REQUEST

Current Zoning: MX-2 (mixed use district-2)
Proposed Zoning: N2-A(CD) (neighborhood 2-A, conditional)

The petition proposes a residential community of up to ~~71~~ **70** multi-family attached dwelling units.

Staff does not recommend approval of this petition in its current form.

# RZ-1.0

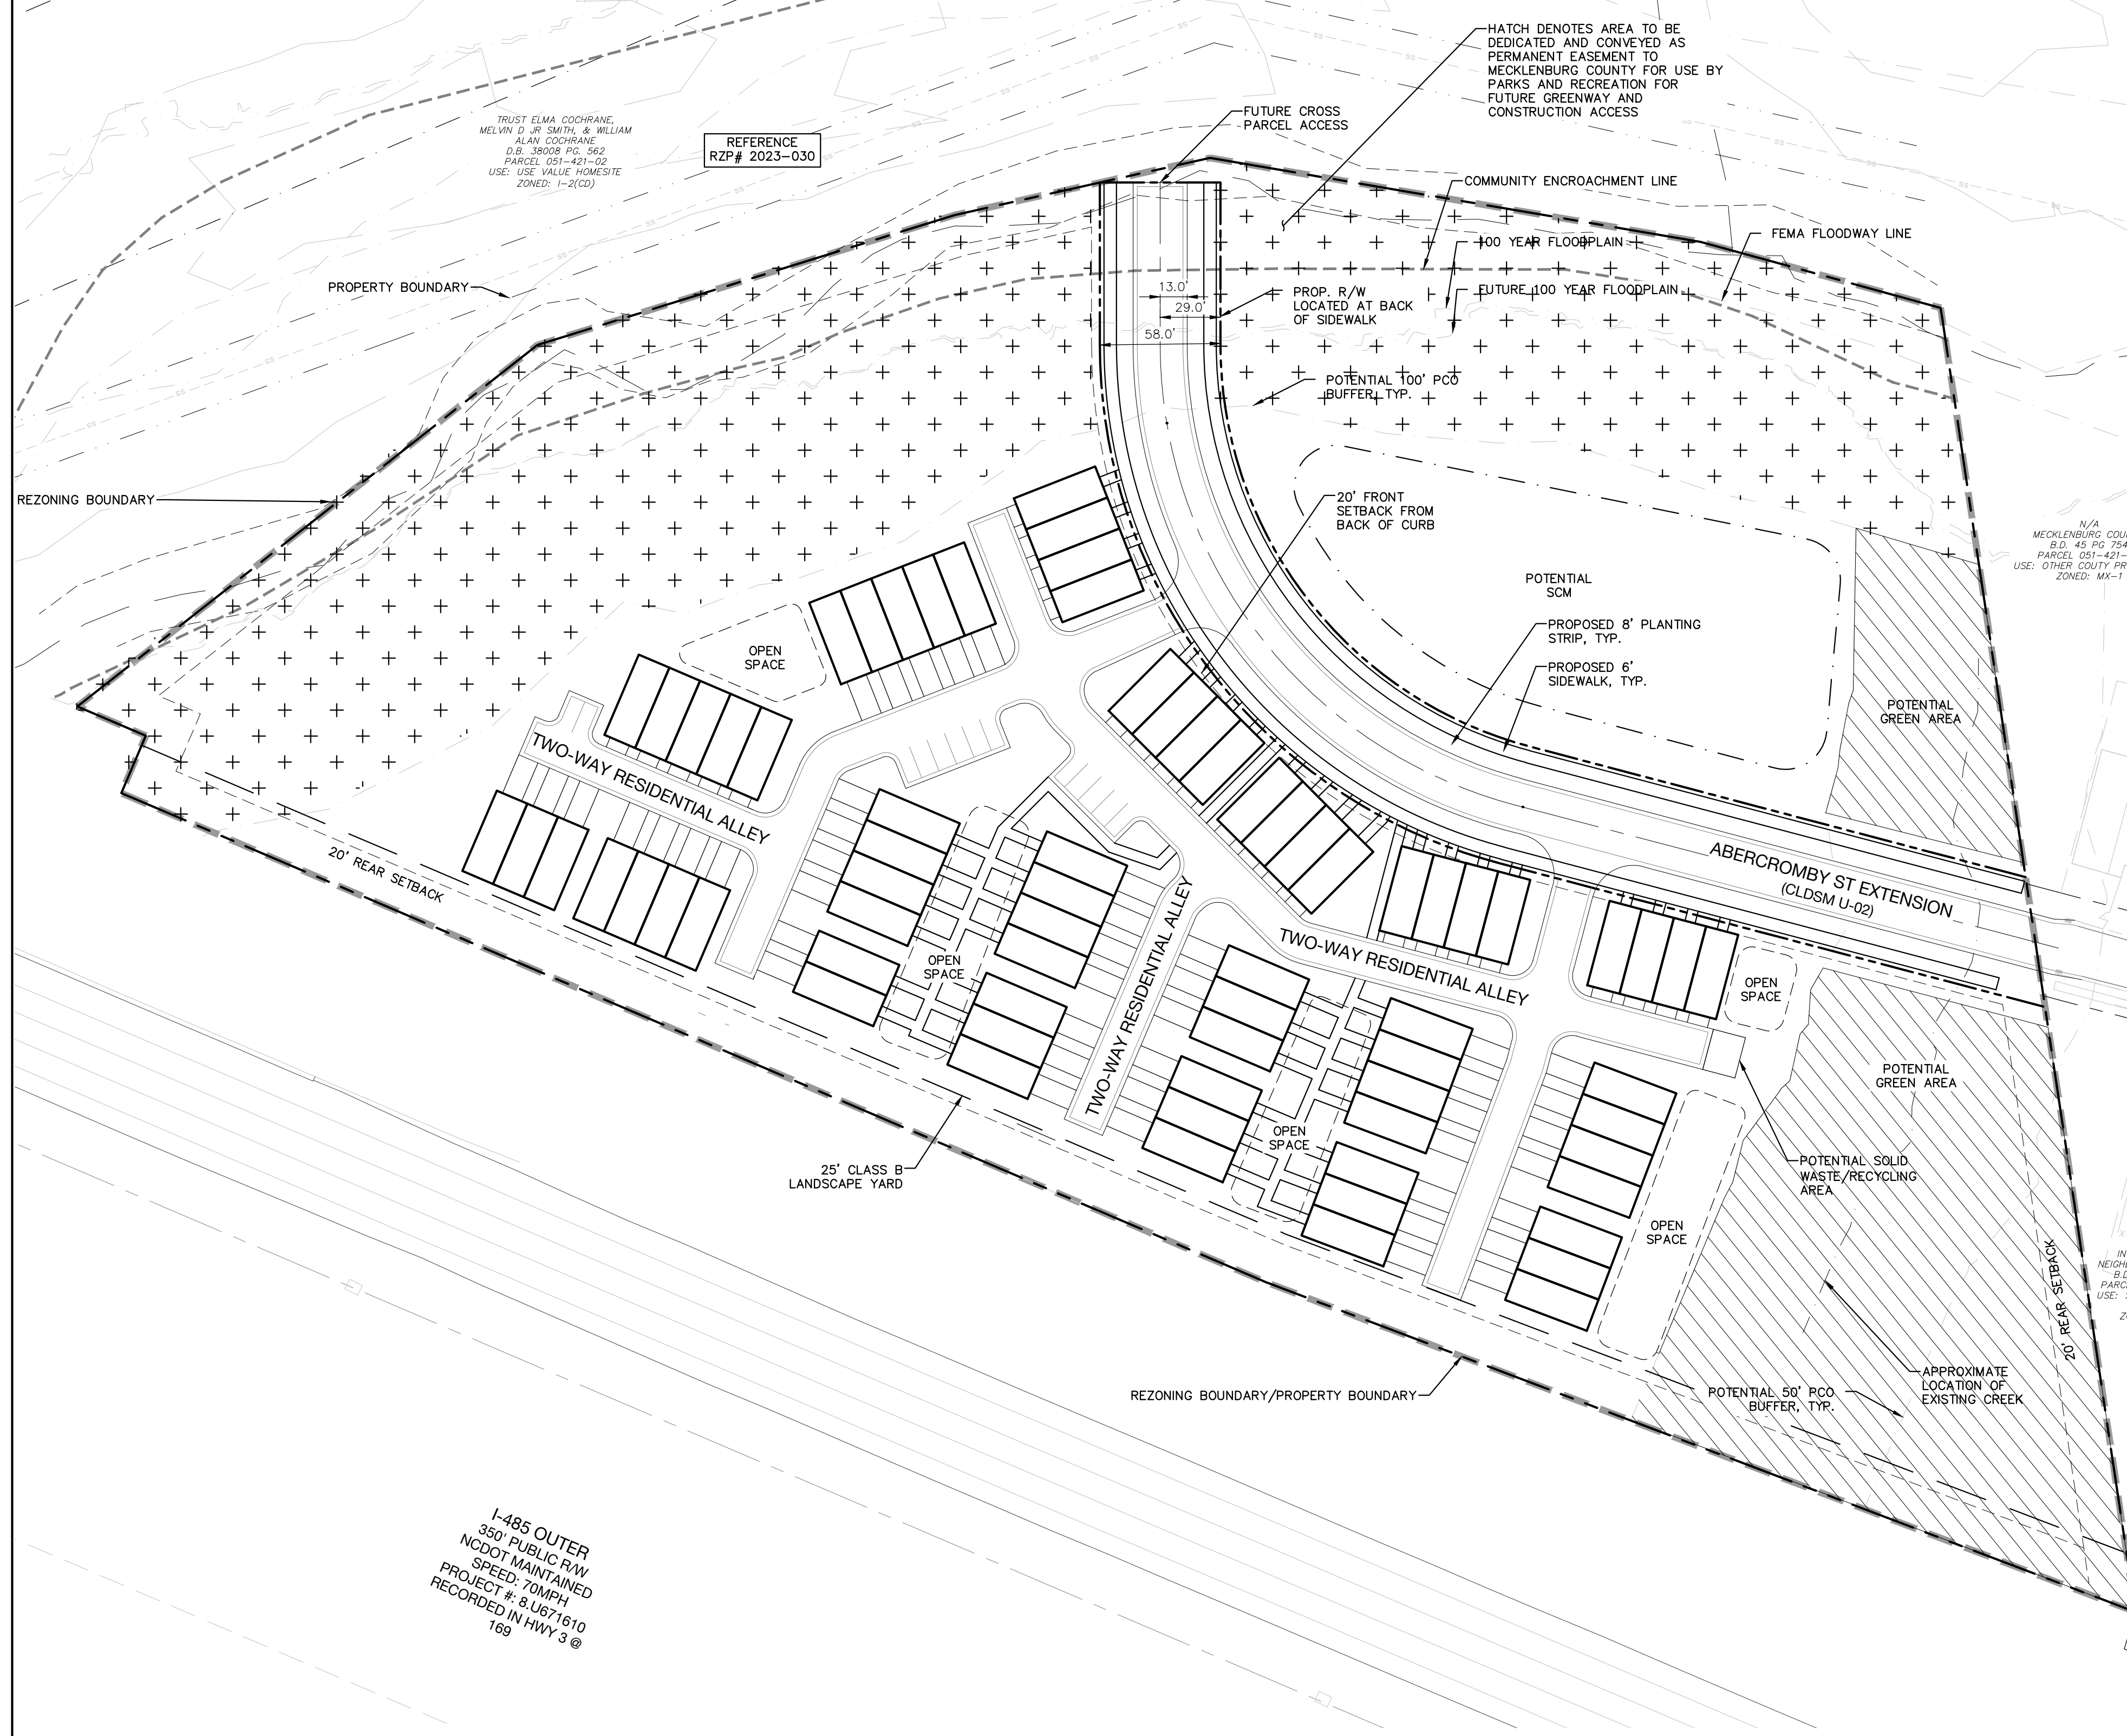
1. ~~Roadway cross-section is called out as USDG U-02. Please revise all reference to roadway standard cross-section to be CLDSM U-02.~~ **Addressed**

3. ~~MCPR requests clarification of the hatched area on the current site plan. The Greenway Easement area to be dedicated and conveyed to Mecklenburg County must extend to and connect to both sides of the public ROW.~~ **Addressed**
4. ~~Green area must be comprised of existing tree canopy.~~ **Addressed**
